**Consultation Response from KC,  
Highways Development Management****2026/92450 Workshop between, 12 & 14/16, Temple Street, Lindley, Huddersfield, HD3 3JG****Demolition of existing workshop and erection of detached dwelling****Date Responded: 28 September 2026****Responding Officer: Sheila Henley****Responding Ref: 2-20SE/33****Recommendation: No Objection.**

Plan ref: 298 (0-) 02 - Scheme As Proposed

Revision	Description	Issued	Checked	Date
Client: Mr & Mrs McGowan				
Project: The Workshop, Temple Street, Lindley.				
Drawing: Scheme As Proposed				
Drawing Status: PLANNING				
Date: FEB 26	Scale @ A1: 1:100	Drawn by: AB		
Project No: 298	Drawing No: (0-) 02	Revision:

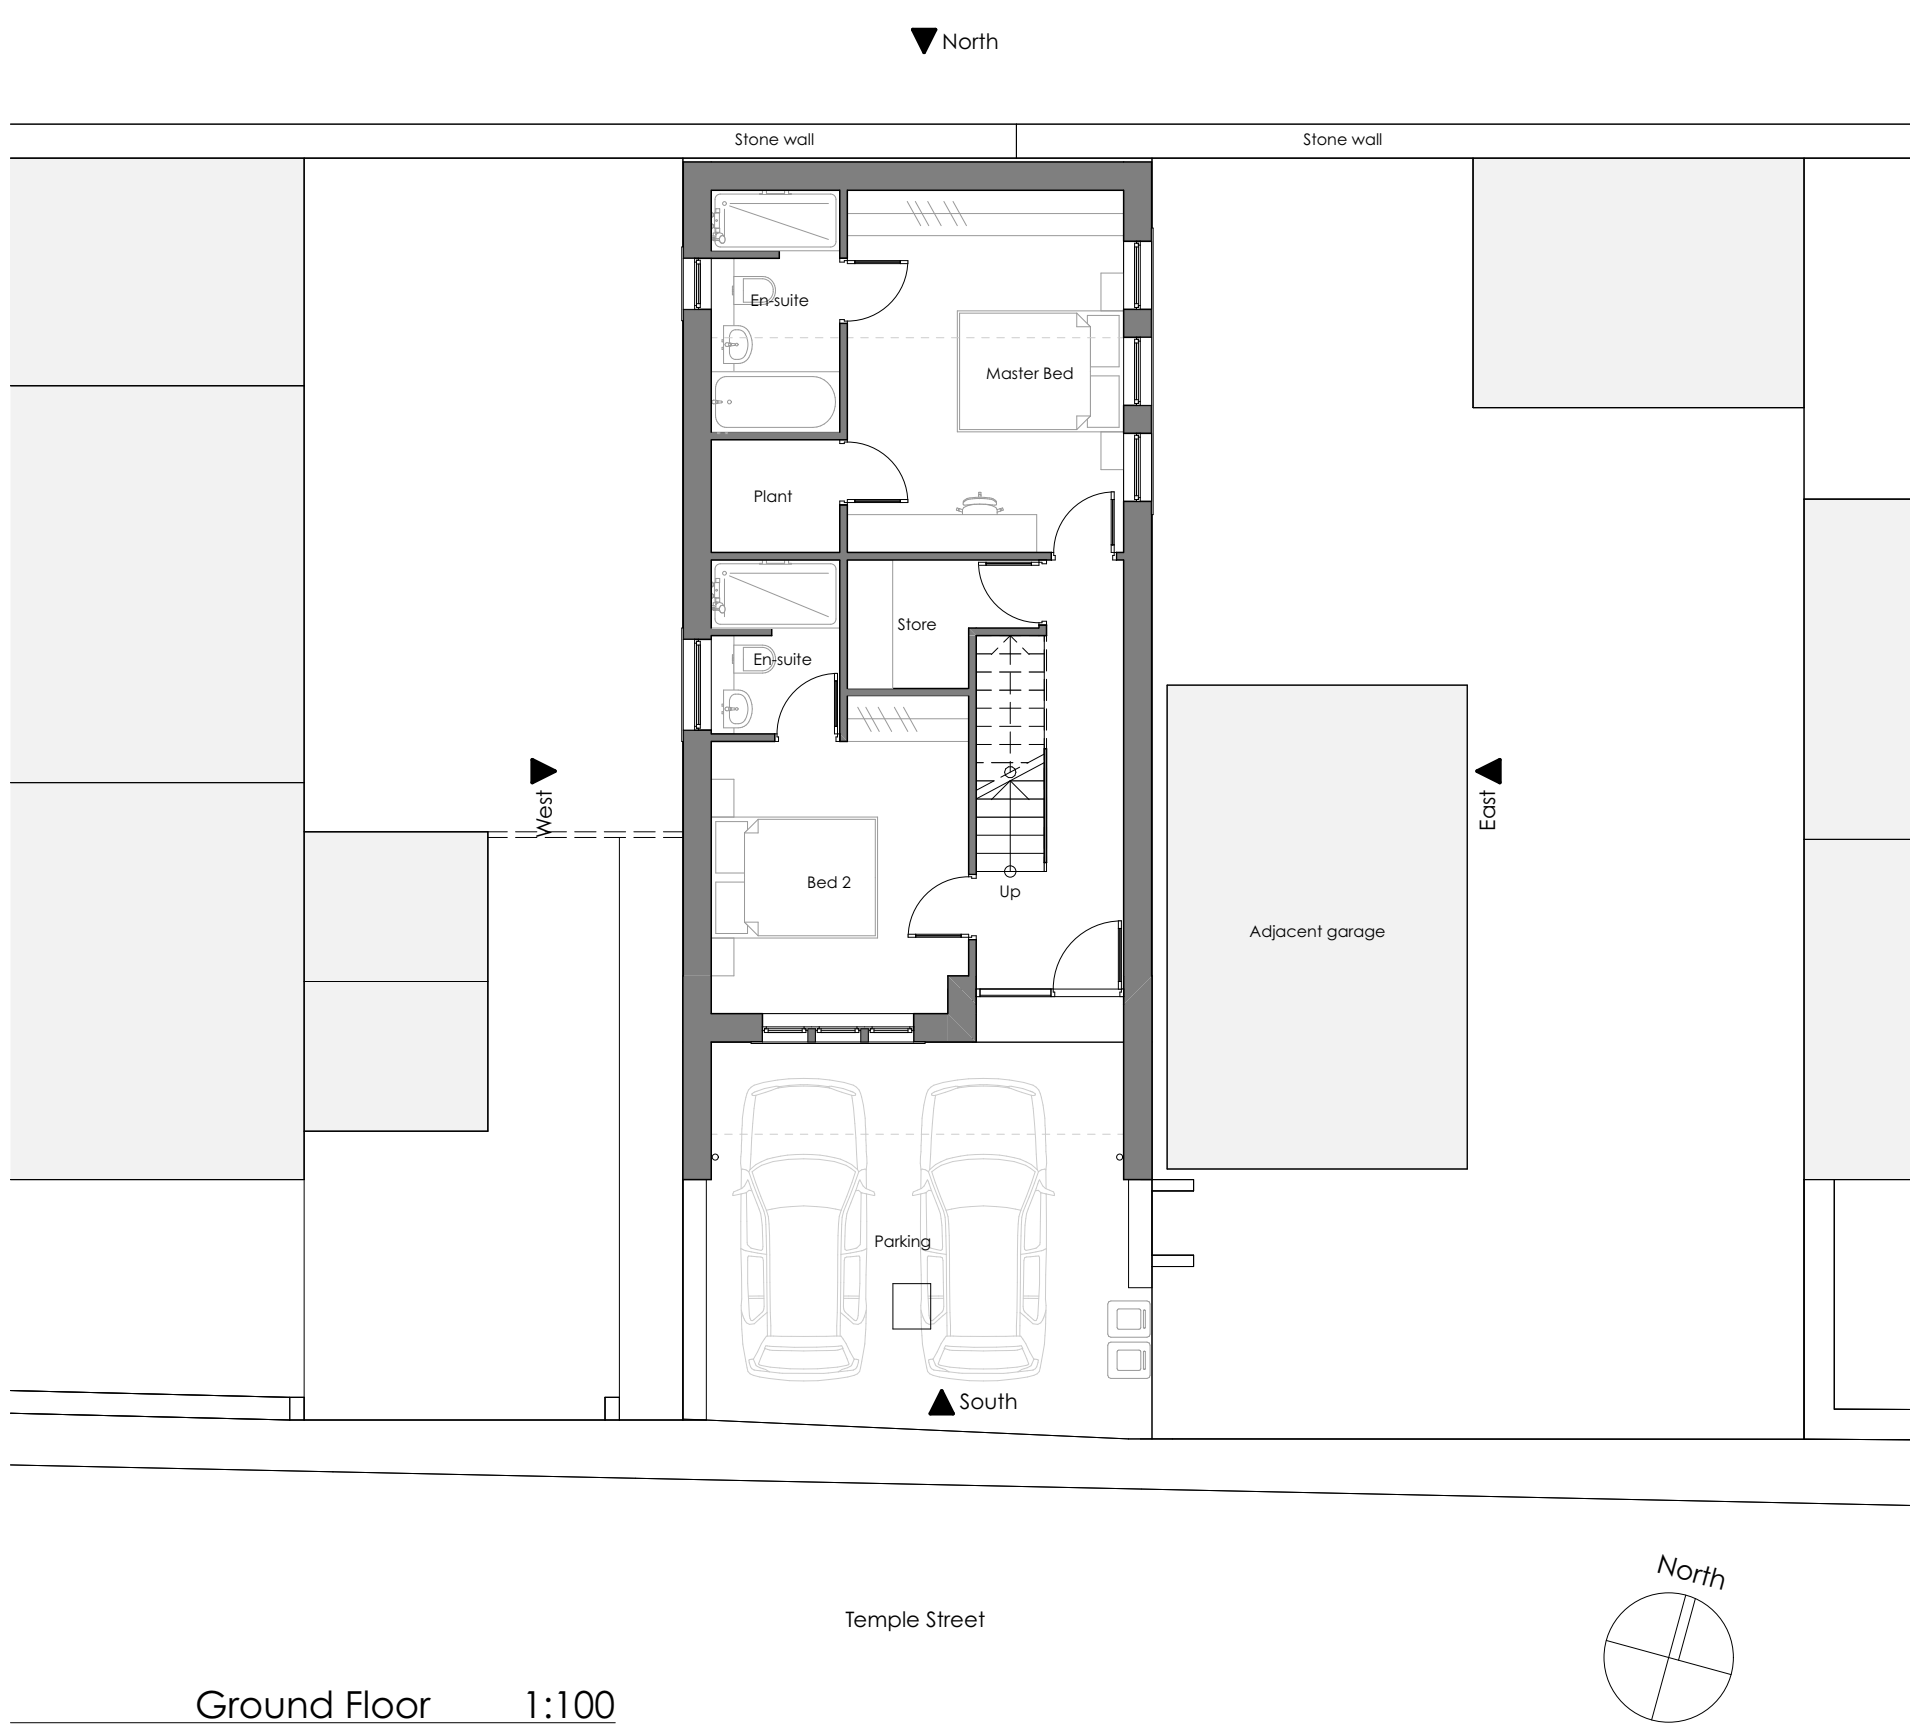
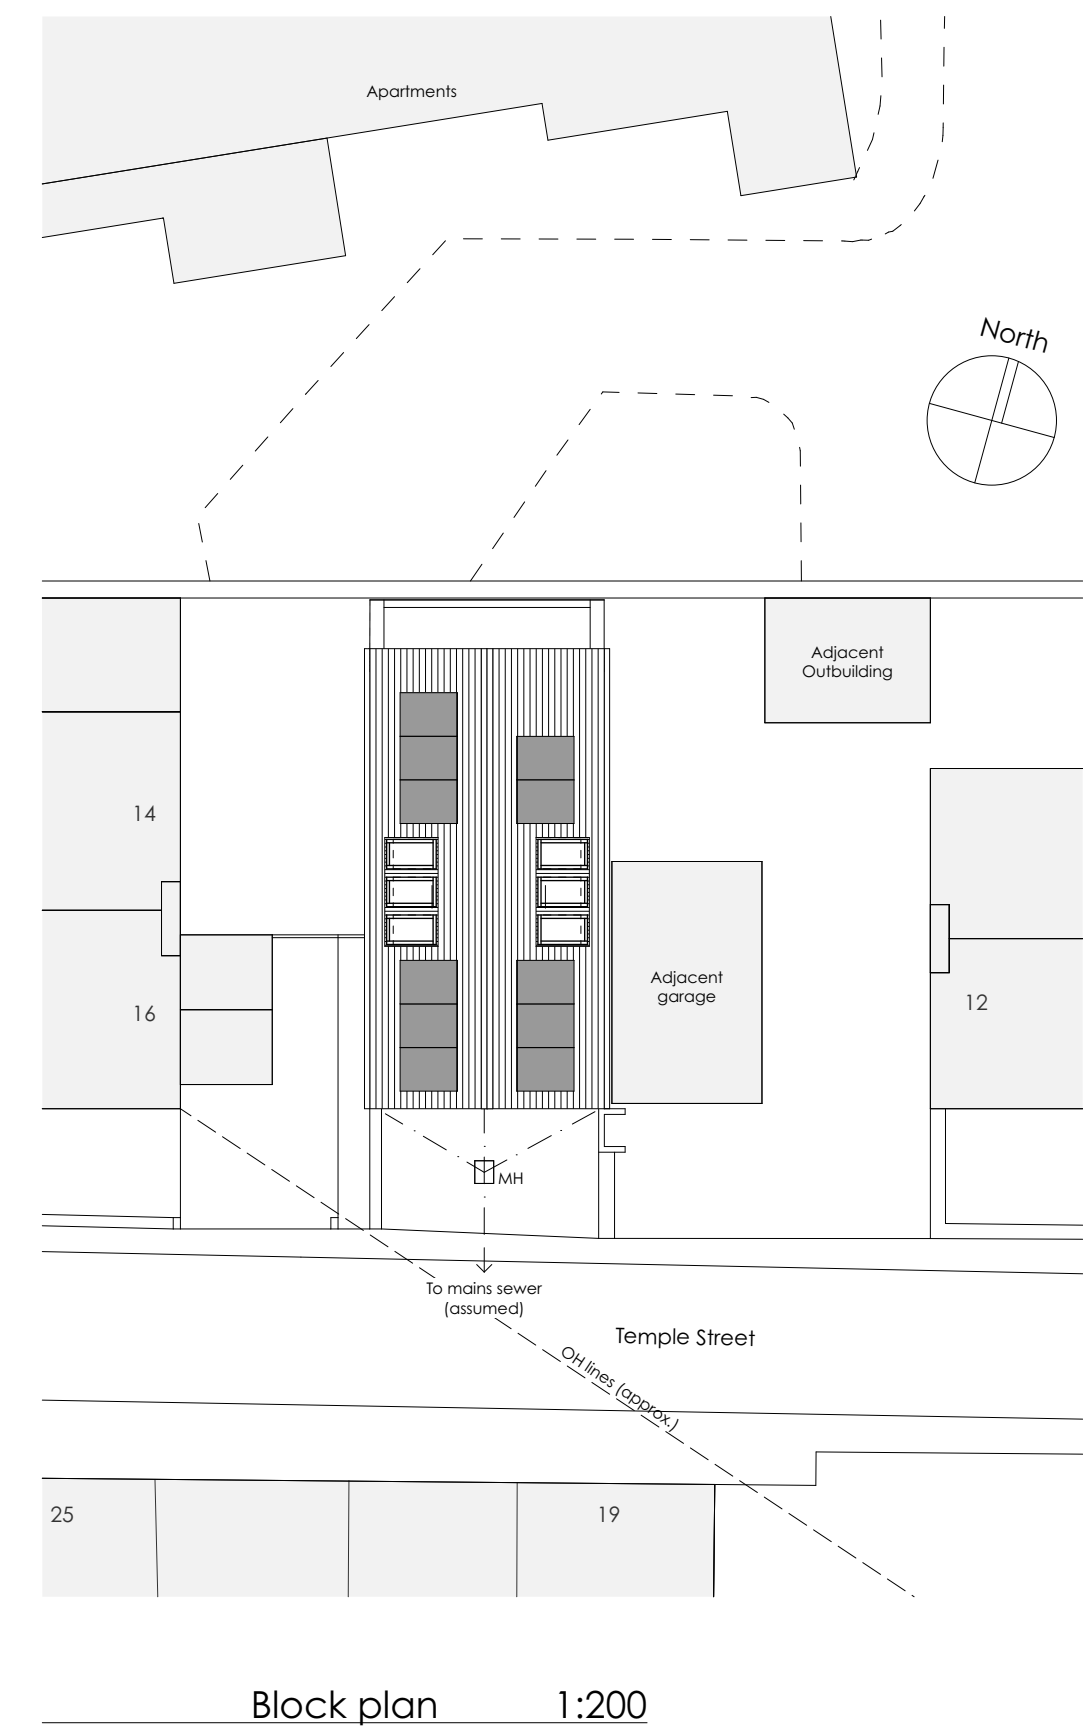
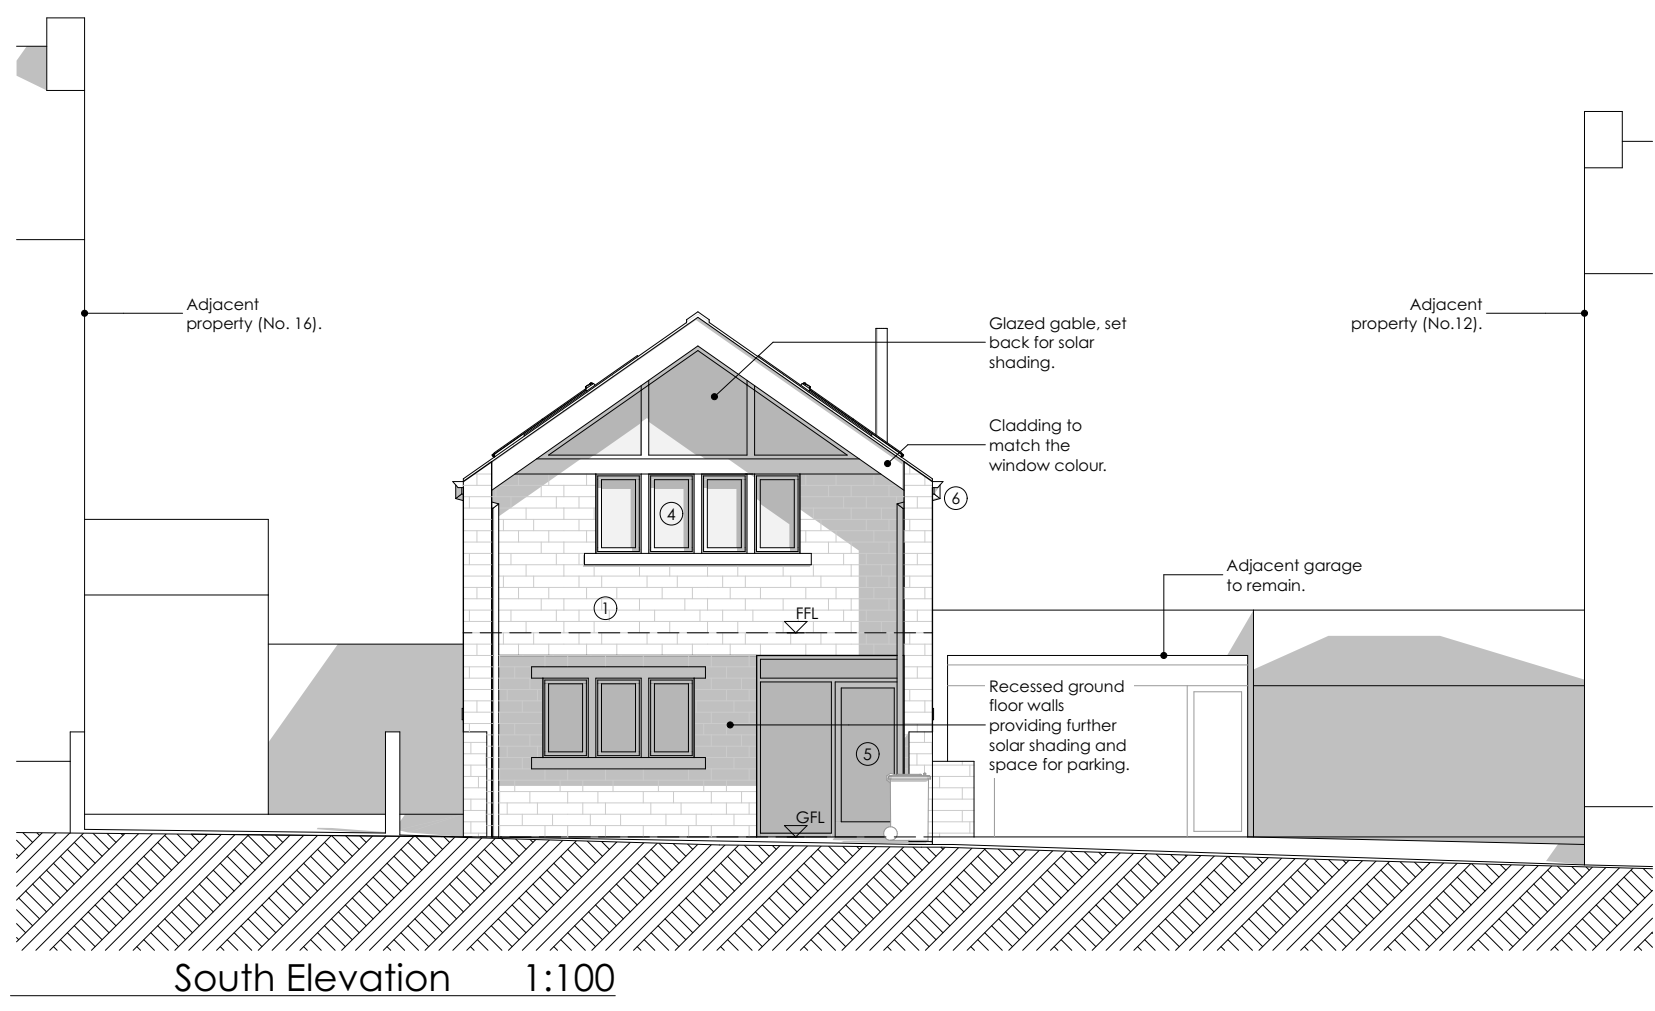
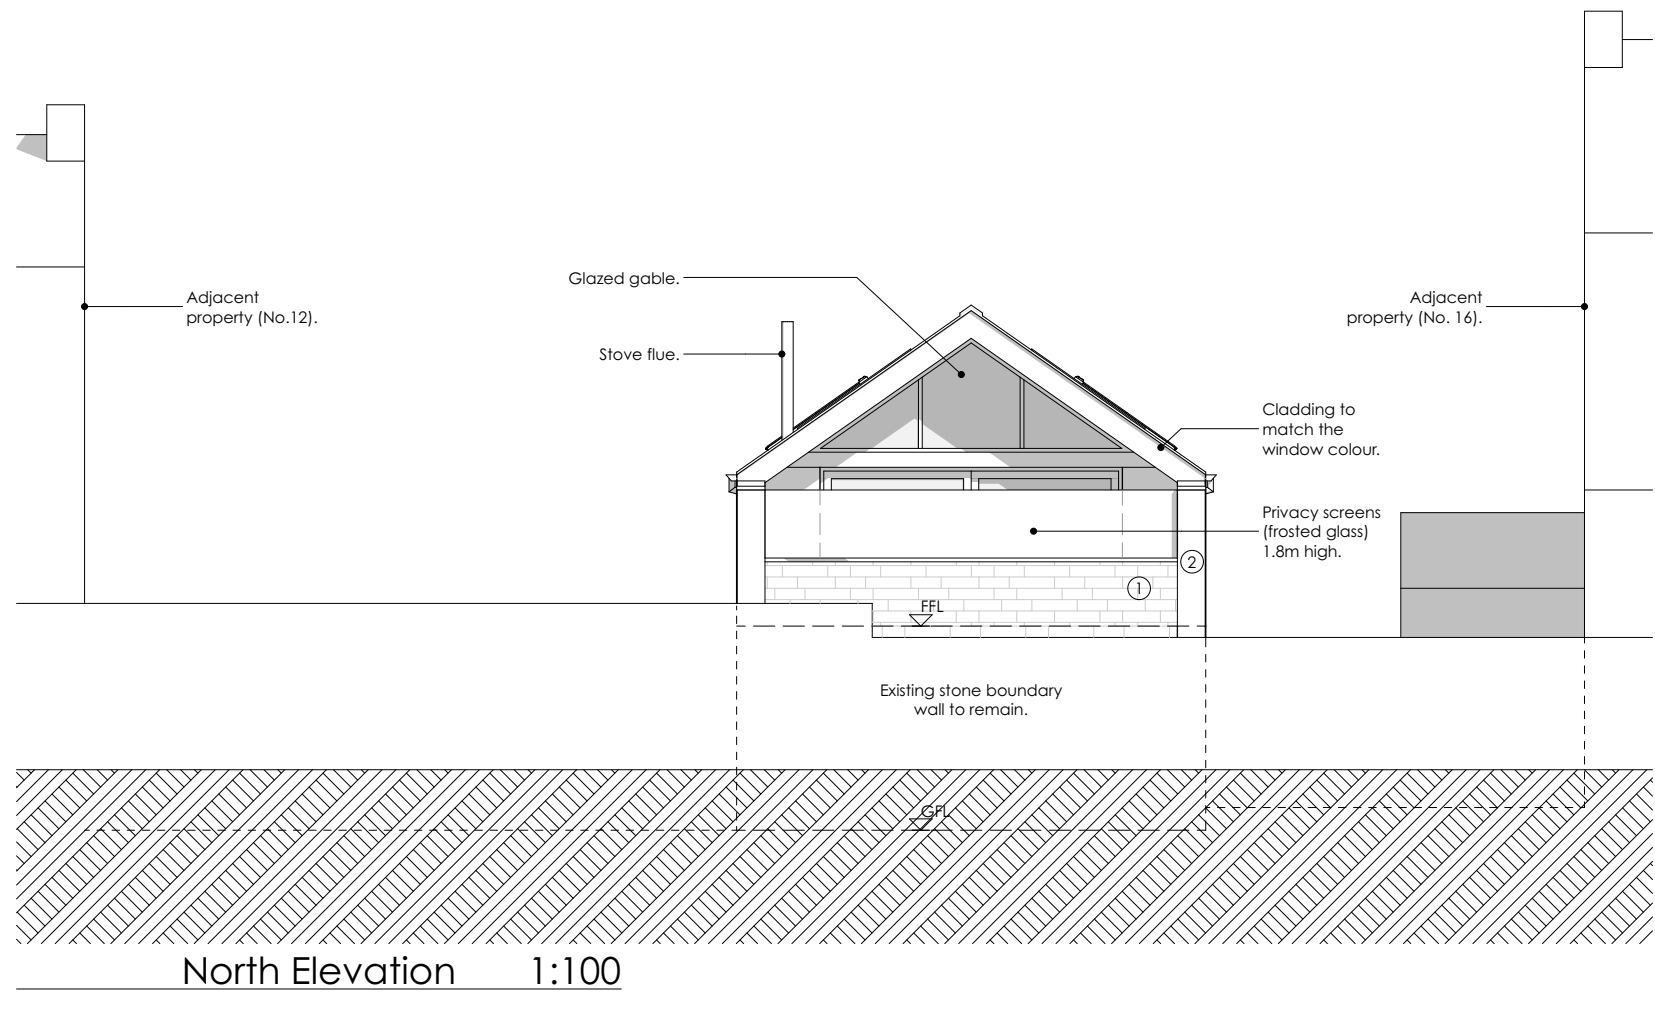
There appears to be no space for cycle parking to meet policies LP20 and LP22, support Active Travel and mode choice and as desired within the Kirklees Highway Design Guide SPD at one space per unit or as preferred at one space per bedroom to meet later guidance in LTN1/20.

An electric vehicle charging point is necessary to support LP20 and LP24 for reasons of sustainable travel and lower emissions. Details of its position will be required.

The amount of space is adequate for two cars and usage by pedestrians providing adequate clearance is achieved from the intended window. The amount of car parking would be sufficient for a two bedroomed dwelling in keeping with suggested provision in the KHDG SPD.

Any new areas for hardstanding should be in a permeable surface material.

Accordingly, the proposal is acceptable in highway terms for no objection to be raised. Installation of an evcp is necessary and the provision of cycle parking if there is space.
